City of Albuquerque Stormwater Construction Site Inspection Report

ESC File No.	H17E097	Project Name:	Carlisle Crossing		
NPDES Id. No.	NMR10040K NMR10040H	Location:	2100 Carlisle Blvd. NE		
8/30/2021	Owner	Contractor			
Operator	Carlisle Associates LP	Jaynes Corp.			
Contact name & title	Dave Rosen C/O Joe Bernabeo	Jesus Ortiz			
e-mail	jbernabeo@rosenmgmt	jesus.ortiz@jaynescorp.com			
Contact Phone #	505-304-4516	505-345-8591			
COA Inspector	Doug Hughes	Start/End Time:	2pm		
Construction Phase:	Excavation/grading				
Type of Inspection:	Regular	Storm Event	Past Storm Event >0.25"	311/Complaint	Follow Up
Weather at time of inspection?		clear		Temperature: ~	93
Estimated date of last storm 0.25" or greater		n/a

TEMPORARY EROSION AND SEDIMENT CONTROL PLAN

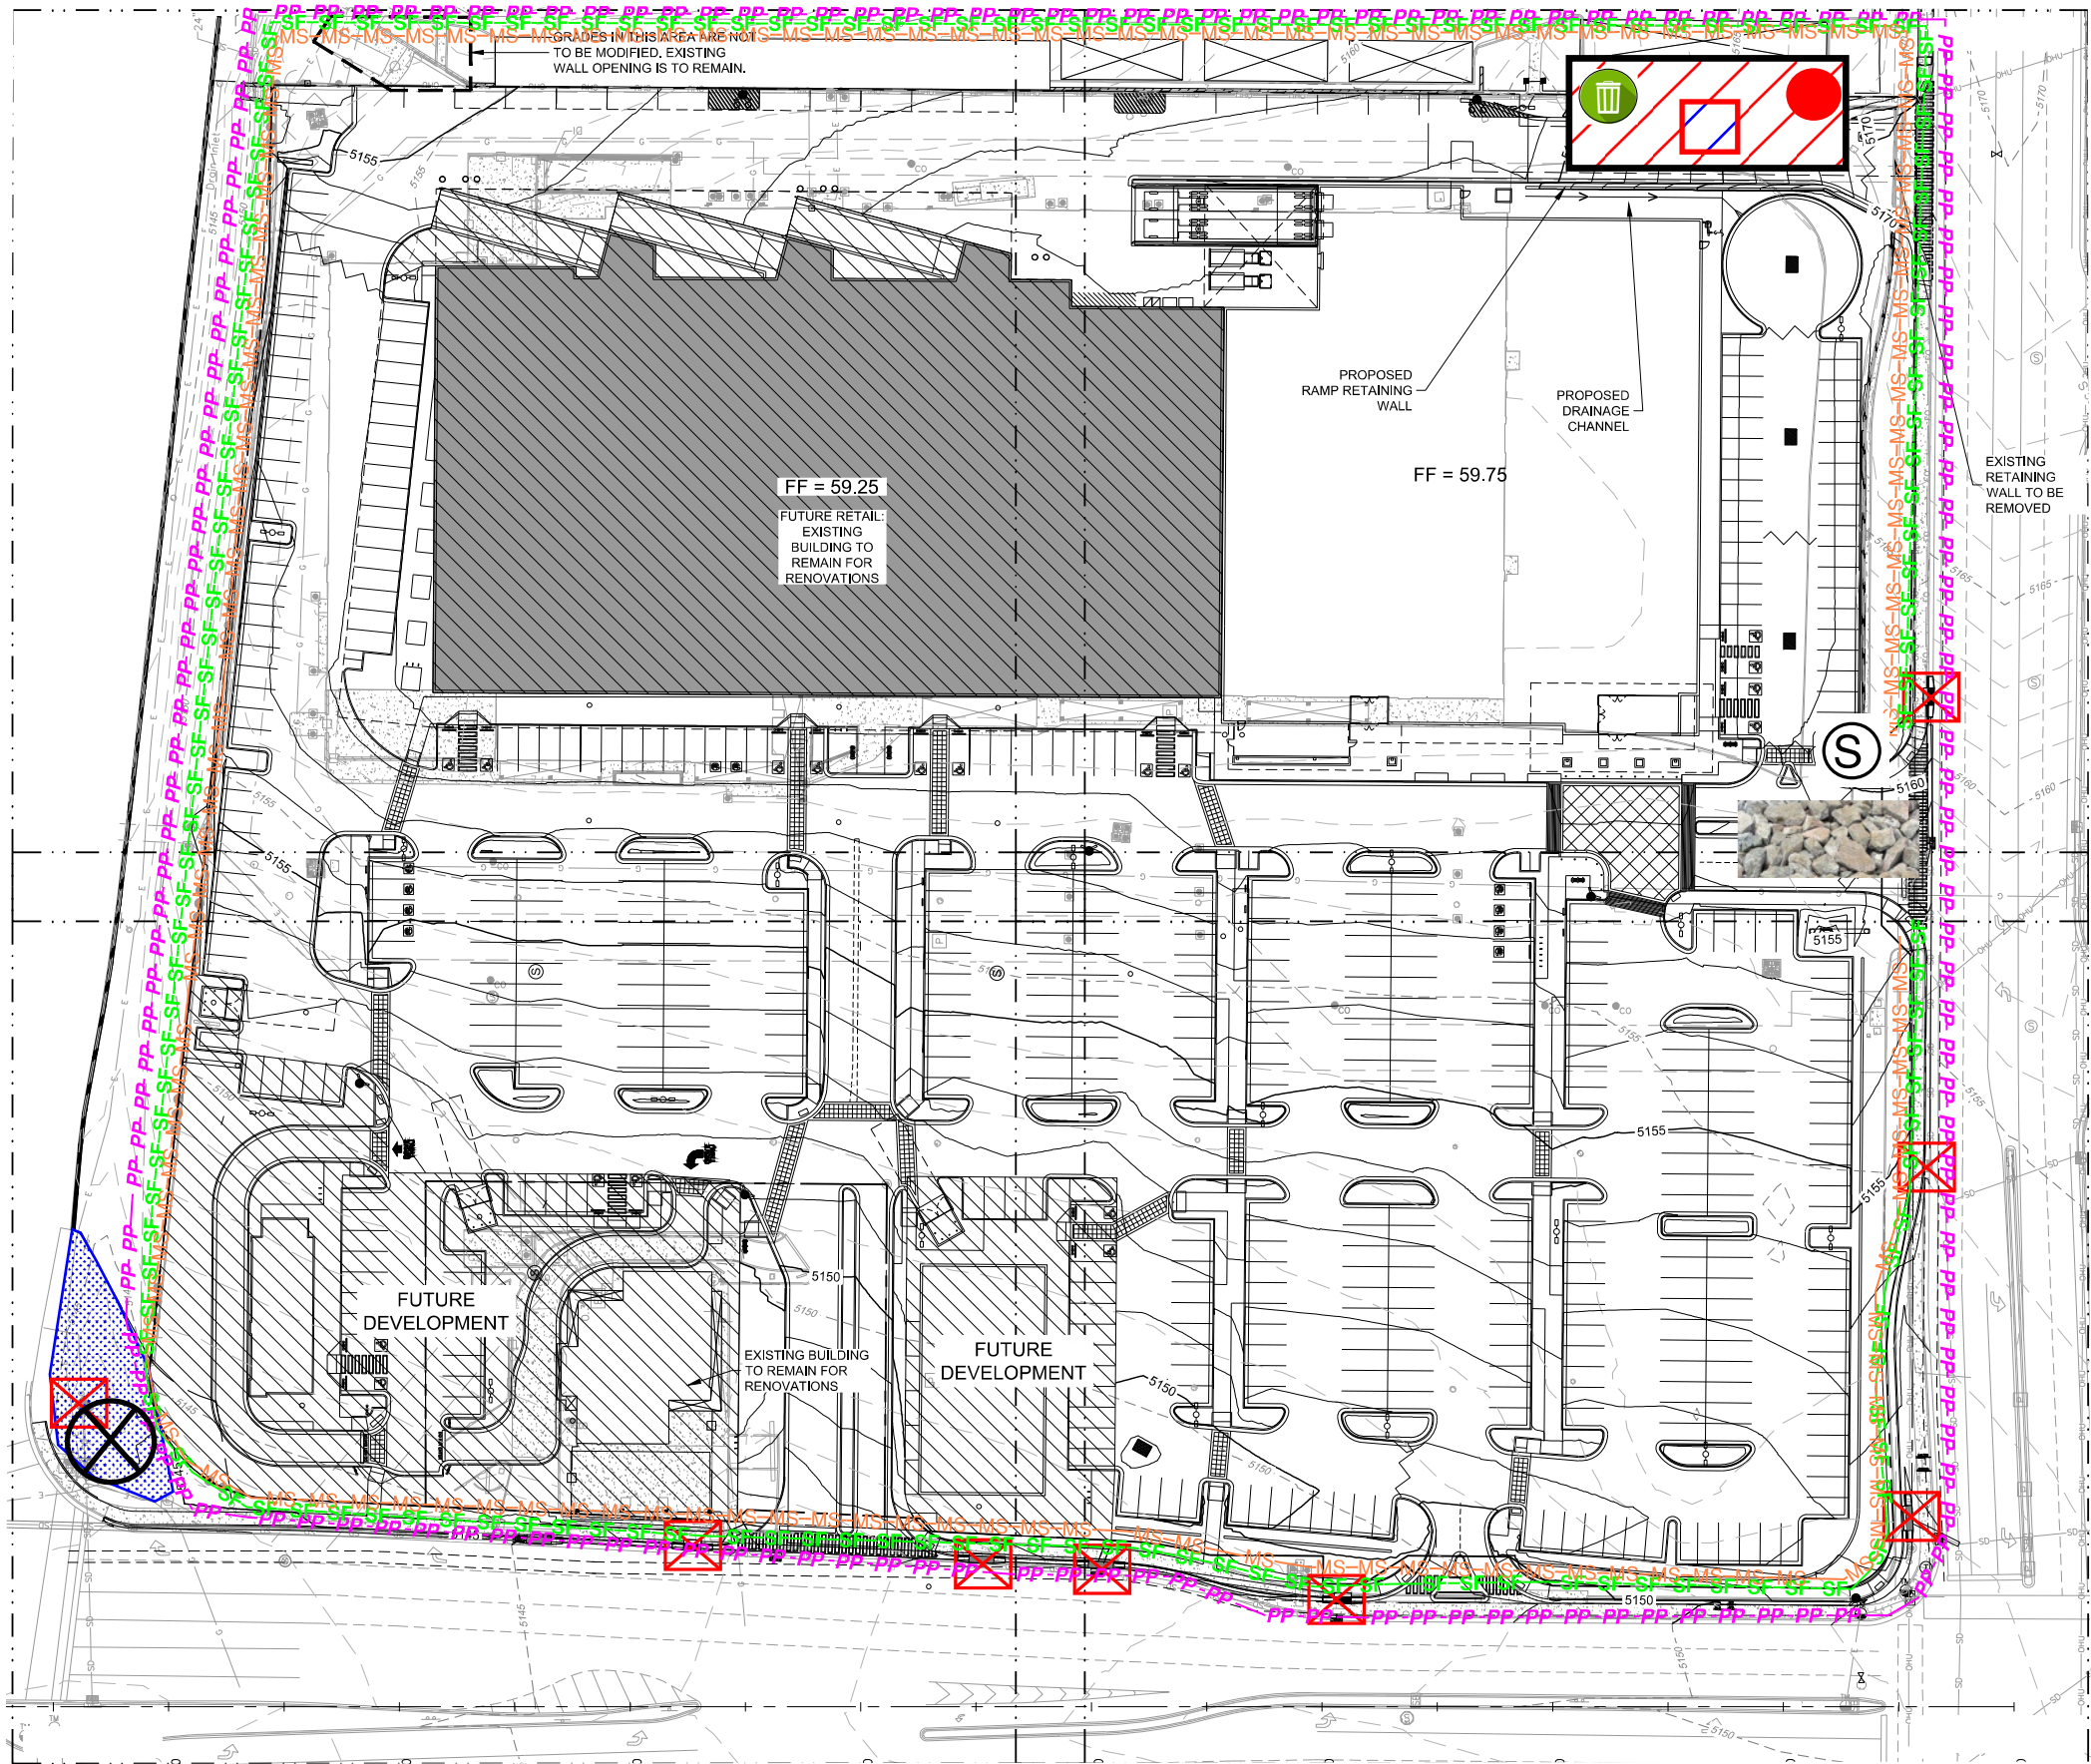
Item Number	Deficiency/ Corrective Action				
1	NPDES Permit coverage is not Posted.				
2	BMPs are incomplete. Sediment traps and diversion berms are missing. Silt Fence alone is not adequate for concentrated flows from these large drainage areas.				
3	SWPPP is not up-to-date. Map out of date and doesn't agree with current condition of the site. No inspection reports or any indication that BMPs have been checked.				
4					
5					
6
